Memorandum

Date: May 21, 2019

Re: Addendum to SD-18-00001 Williams (Shoreline Development Permit Application)
GP-18-00018 Williams (Grading Permit Application)

Manastash Creek Bridge & Driveway at Williams Property

<p>MITCH AND JULIE WILLIAMS (OWNER) 7501 MENASTASH ROAD ELLENSBURG, WA 98926 509-899-0168</p>	<p>MANASTASH CREEK BRIDGE AT WILLIAMS PROPERTY</p>
<p>PAUL TAPPEL (ENGINEER) 3100 - 243rd STREET SW BRIER, WA 98036 425-482-6420</p>	<p>STEEL BRIDGE REQUIREMENTS DRAWING 7</p>

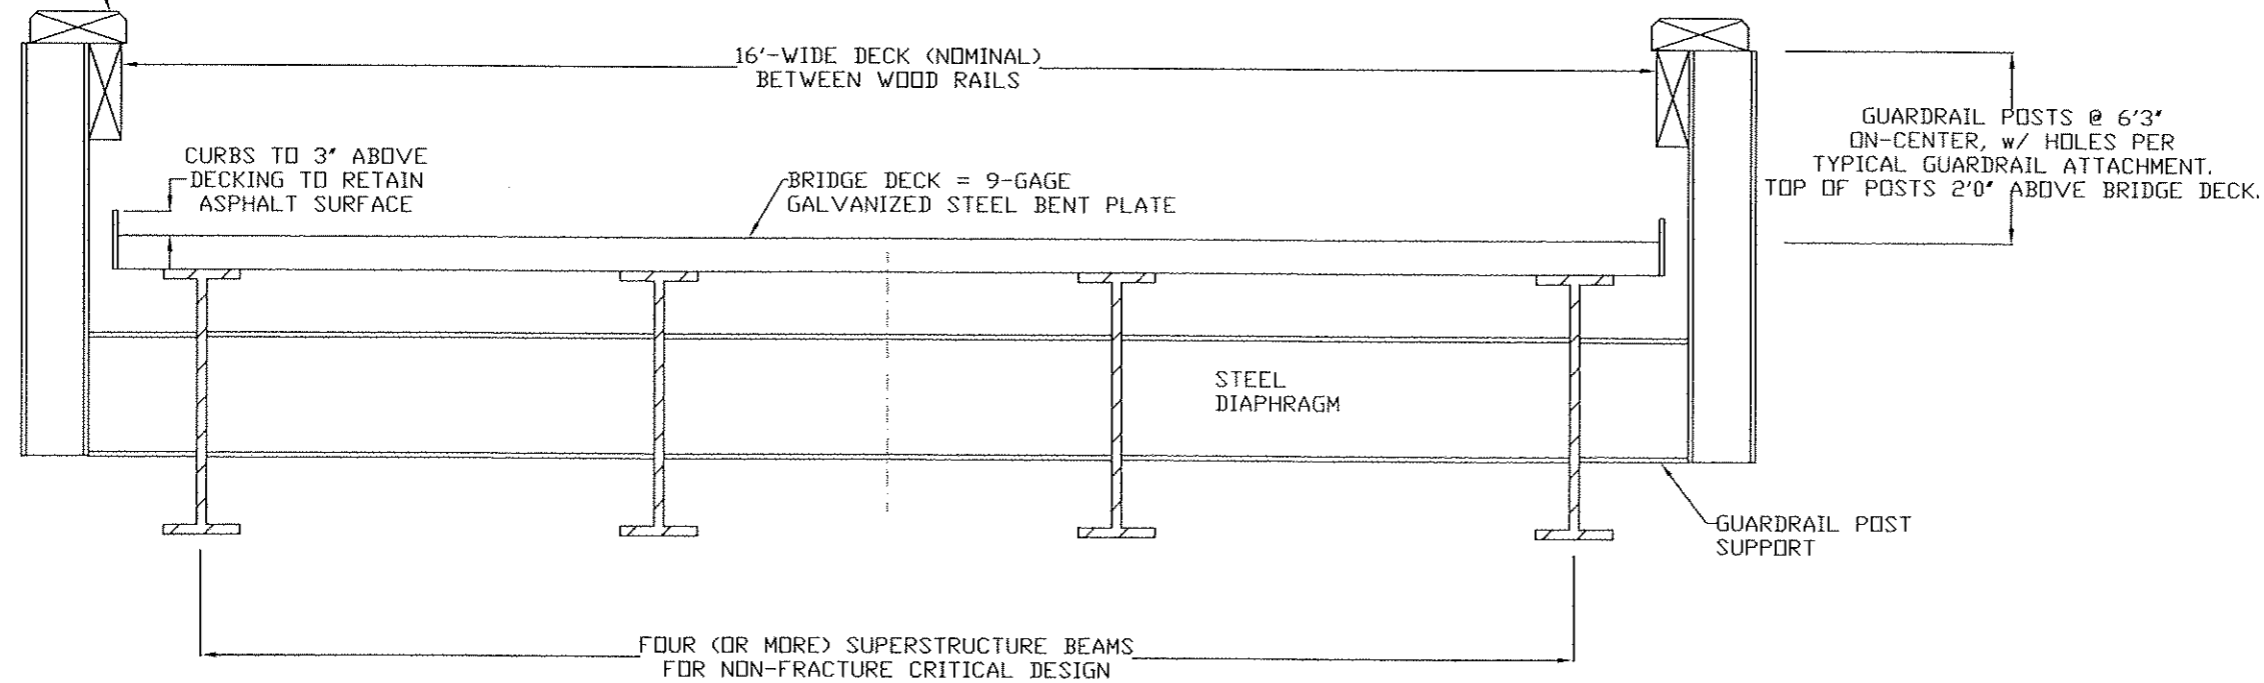
- Bridge deck will be 16'-wide (open) between wood rails, and the entire proposed driveway will be 16'-wide.
- Bridge design drawings, and driveway site plan, profile & sections are all in one drawing set now, instead of split into two drawing sets.
- A few additional notes are listed on Drawing 2 (Basis of Design) to combine the proposed bridge with driveway design, floodplain considerations, etc.
- All drawings are dated April 2019, and this drawing set completely replaces previous drawing sets.

The only changes from previous design submittals are that the bridge deck will be 16'-wide (vs. 14'-wide), this deck will cast a slightly larger shadow over Manastash Creek, and pre-cast concrete footings and backwalls are 2'-longer to support the wider bridge deck.

DRIVEWAY AND BRIDGE SITE PLAN  
DRAWING 10

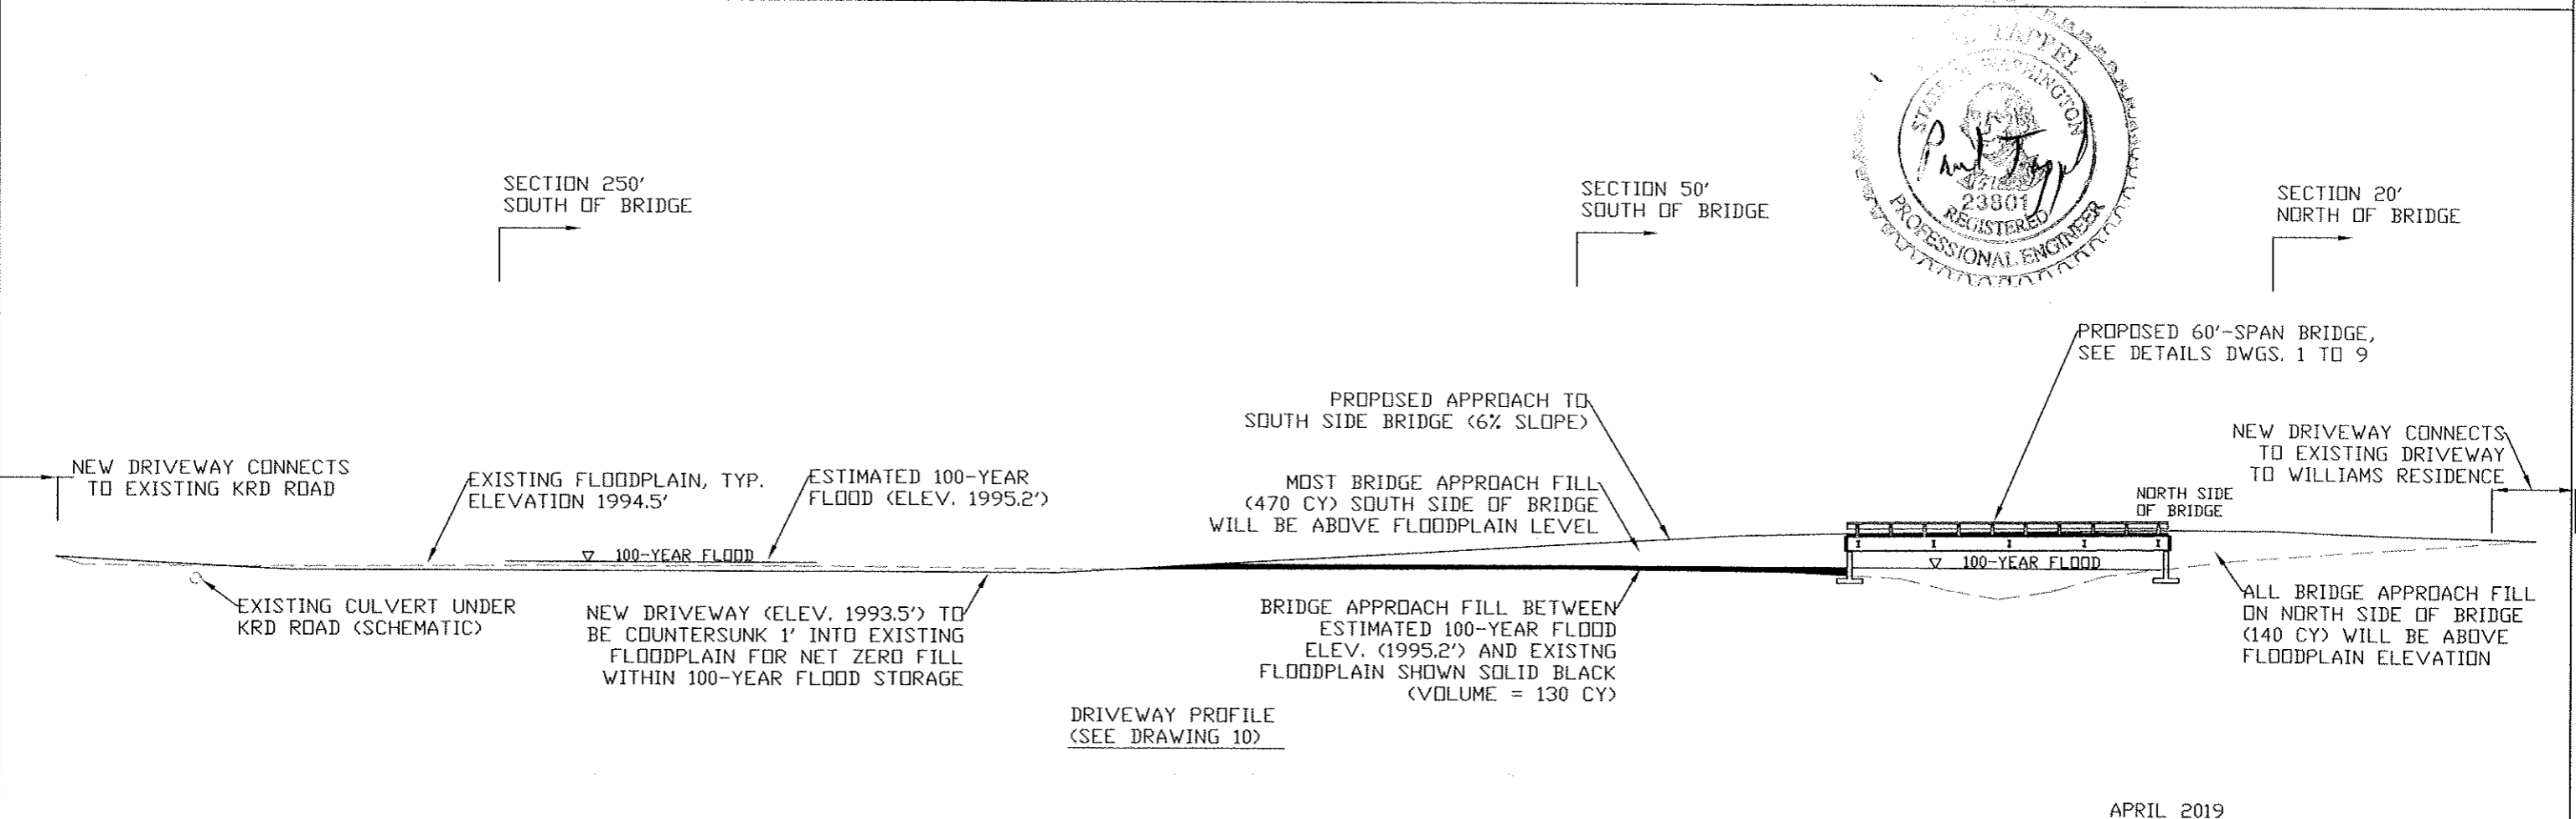
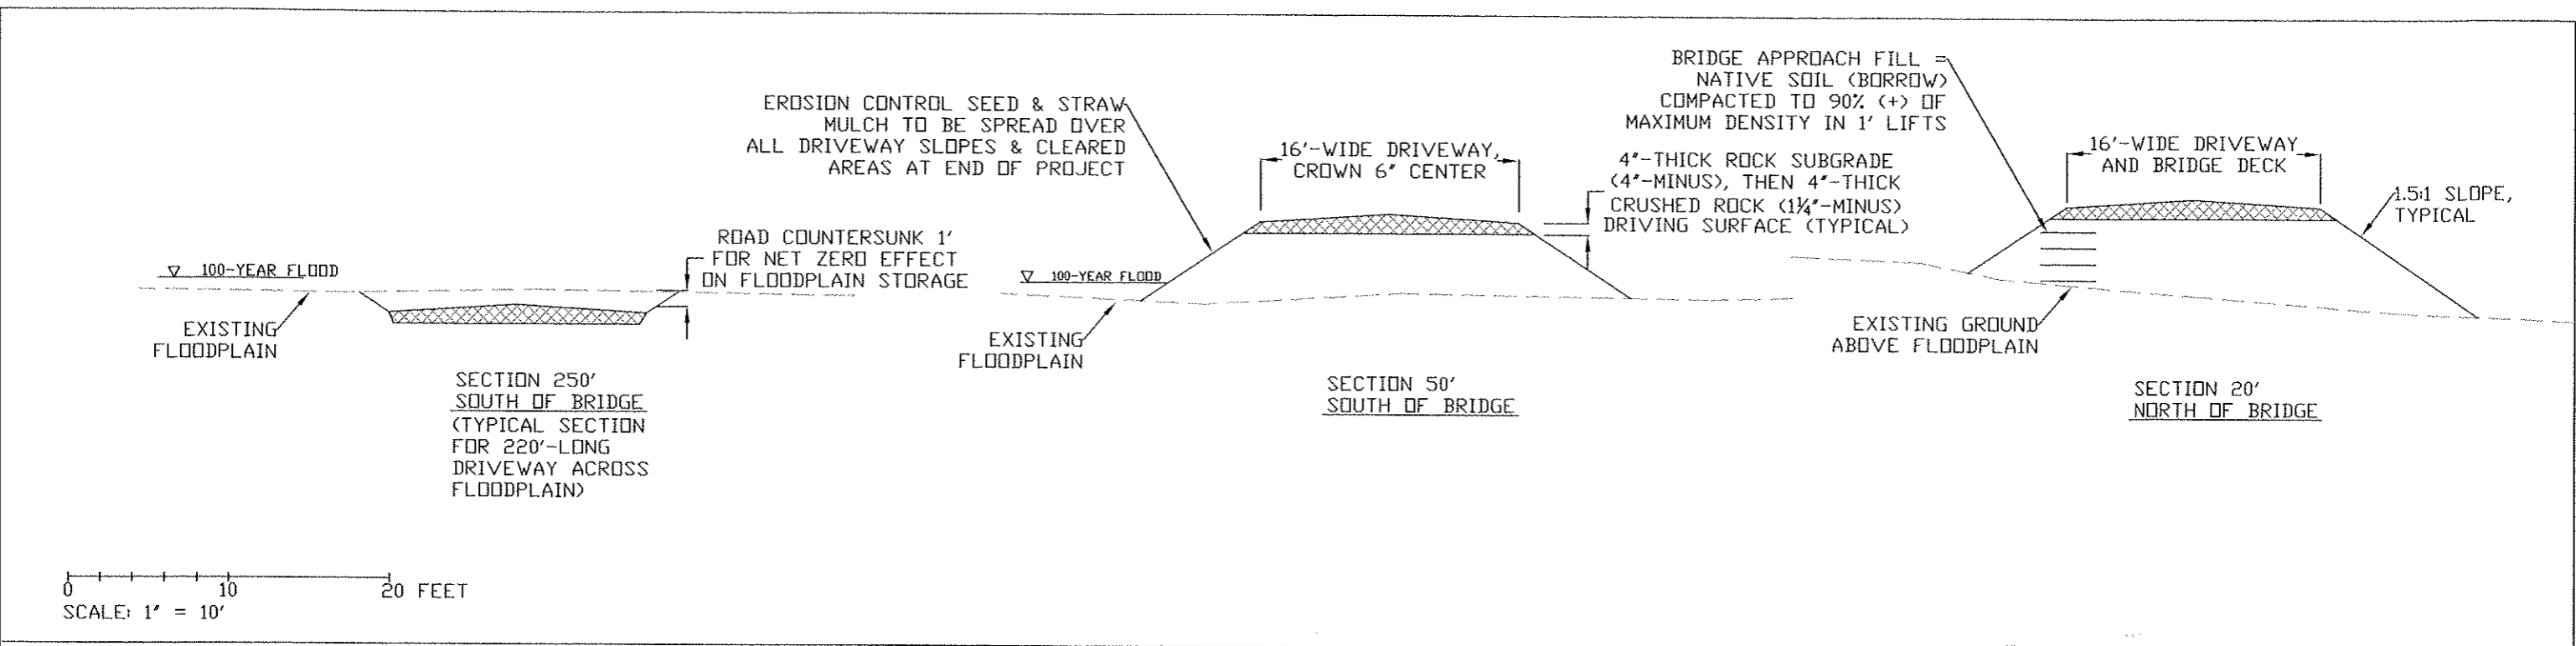
I checked back at my calculations and notes for estimates of disturbed areas, clearing, floodplain fill, net zero change for floodplain fill, etc. Since I had used a 16'-wide driveway for all previous estimates and calculations (see Drawing 11, dated March 2019), my calculations for net zero floodplain fill are exactly the same now, as with the previously proposed 14'-wide bridge deck.
